From: David Seer [REDACTED]
Sent: 03 July 2015 17:07
To: Julian House
Subject: Westergate Phase 2.

As regards the soakaway design in relation to ground water levels, both soakaways are 800 deep below the soffit level given on the drawing. This puts the bottom of the soakaways at a level of 9.36m – equal to the highest recorded ground water level. If needs be, we can raise the soakaways marginally, but we are already quite close to the minimum 600mm depth of cover required for the aquacell units.

Revision		Amendment		Approved		Revision Date		Project			
								R/O "Sunnyside", Westergate.			
								Sheet			
								Drainage			
P2	GENERAL AMENDMENTS.			APT		22.04.2015					
P1	FIRST ISSUE			-		27.03.2015

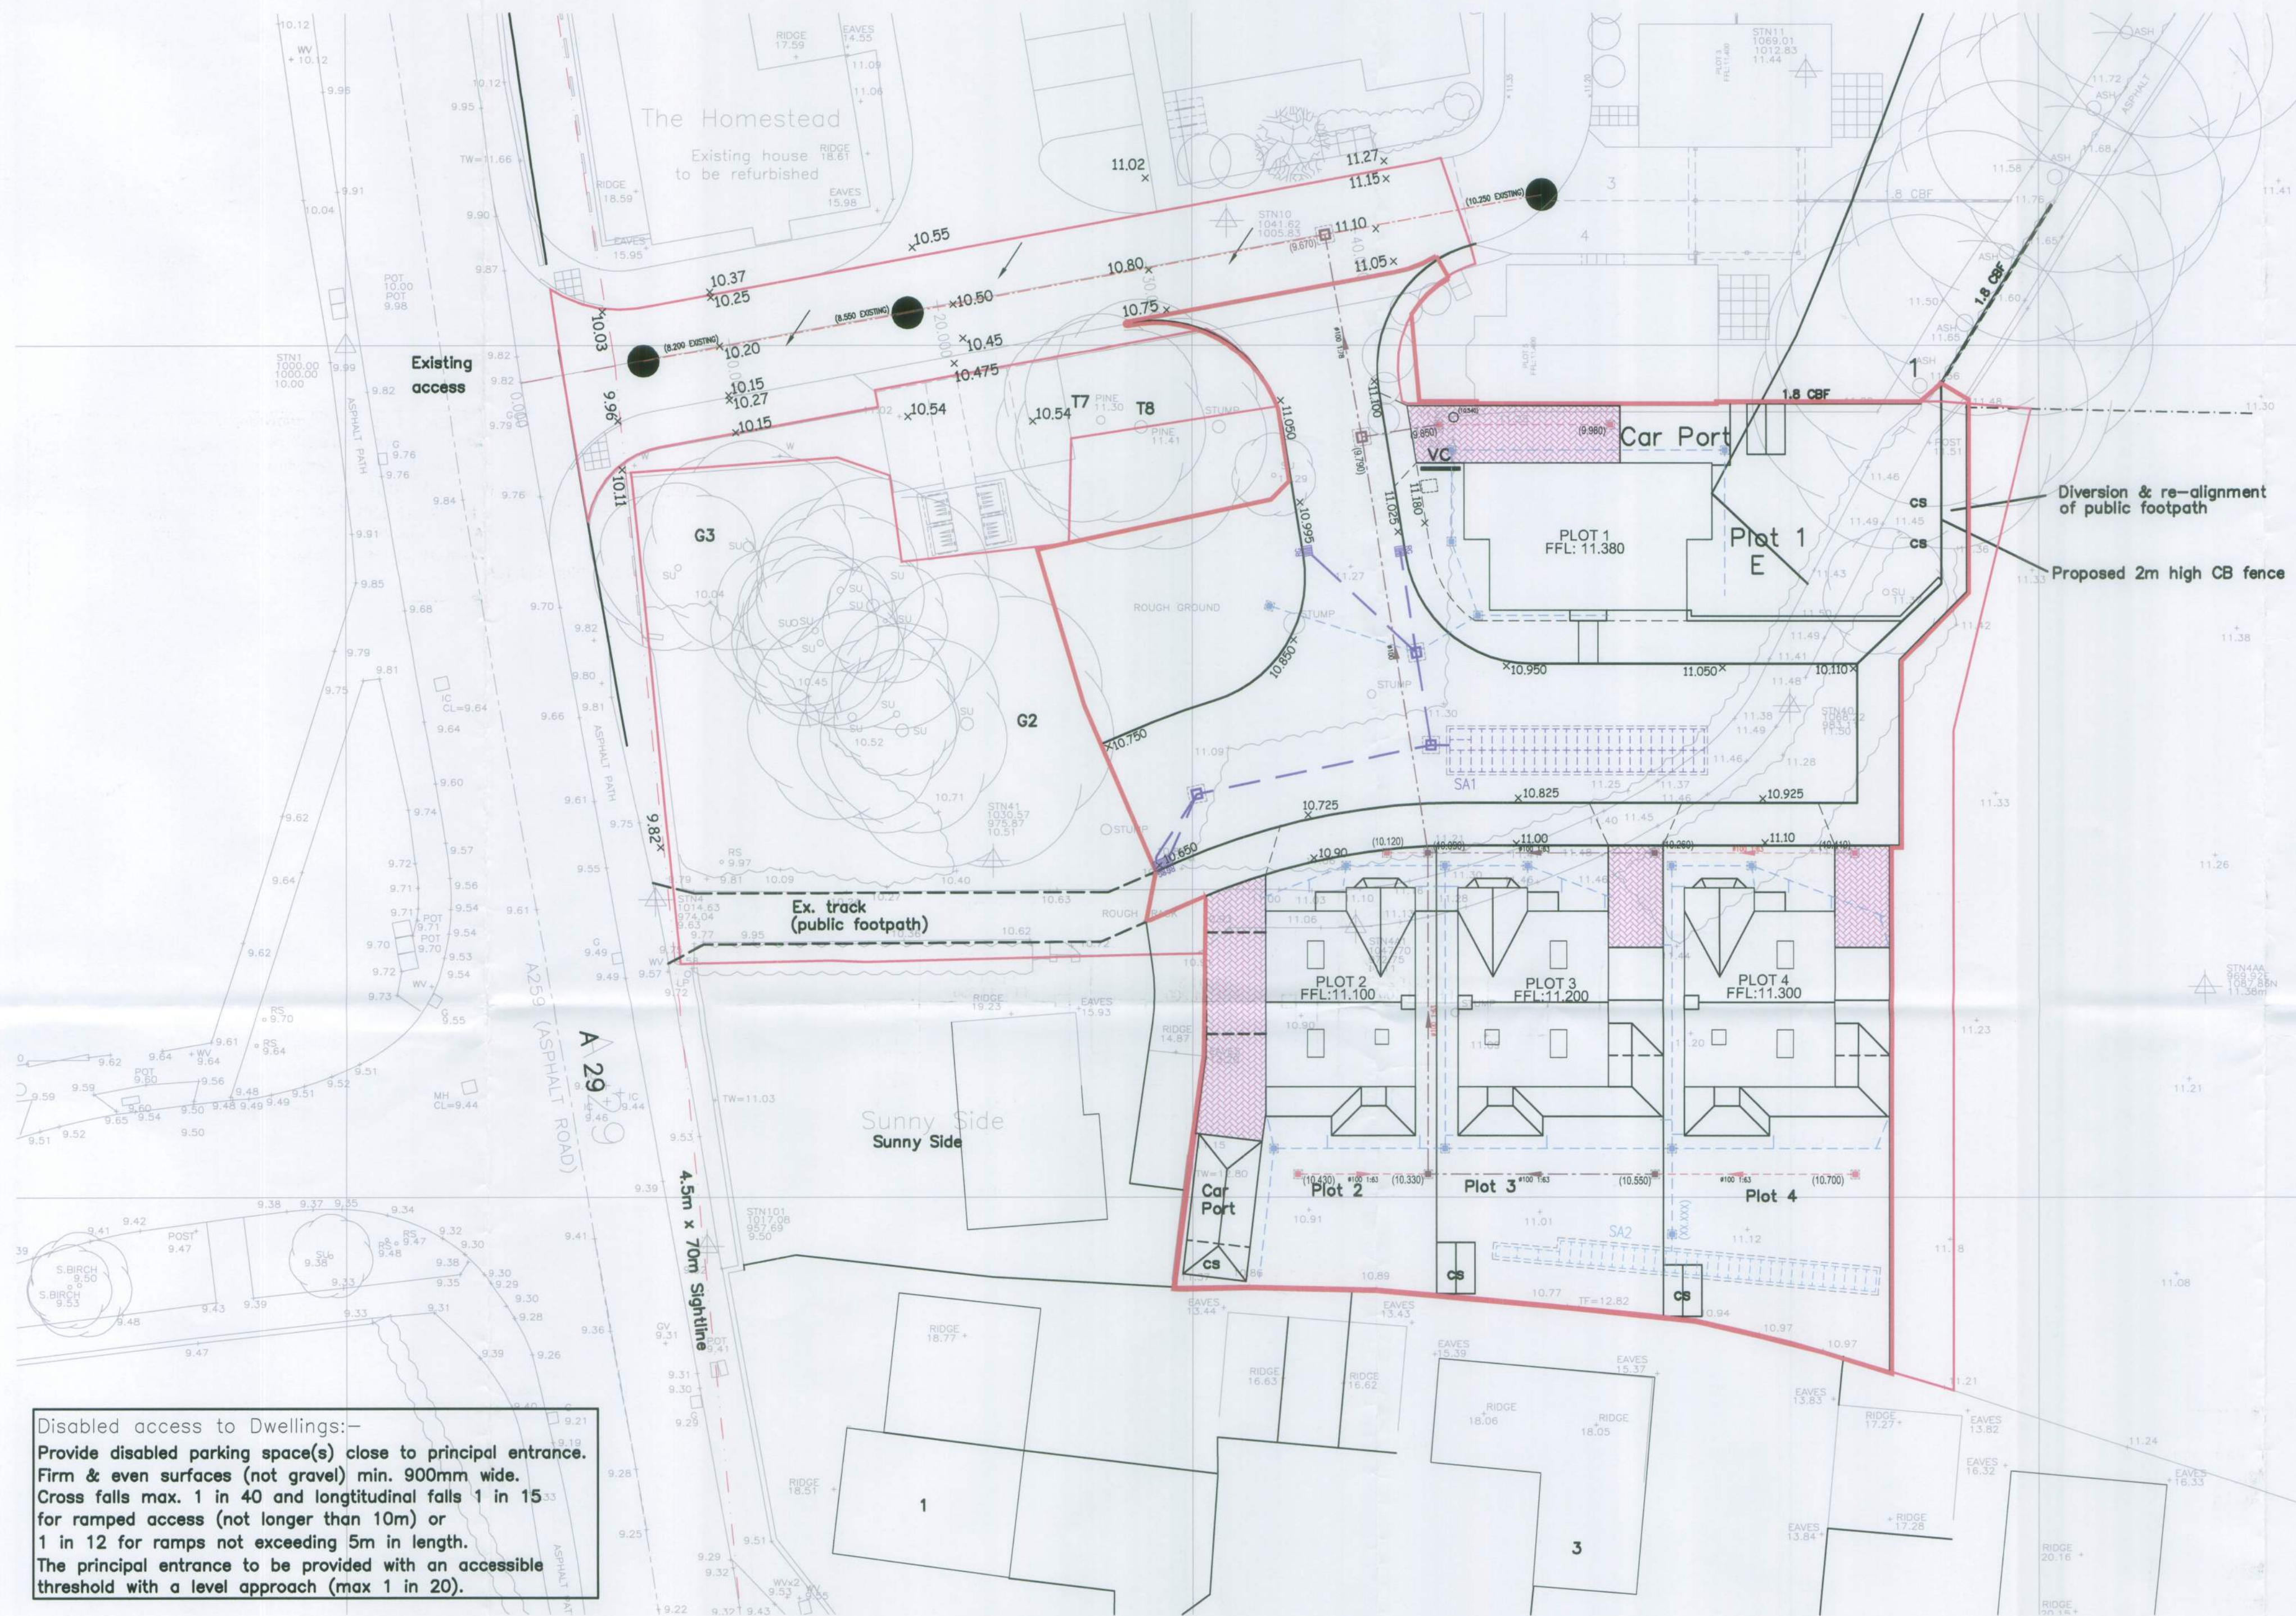
Hopefully this additional information will answer the queries raised by your engineers but please let me know should you require anything further.
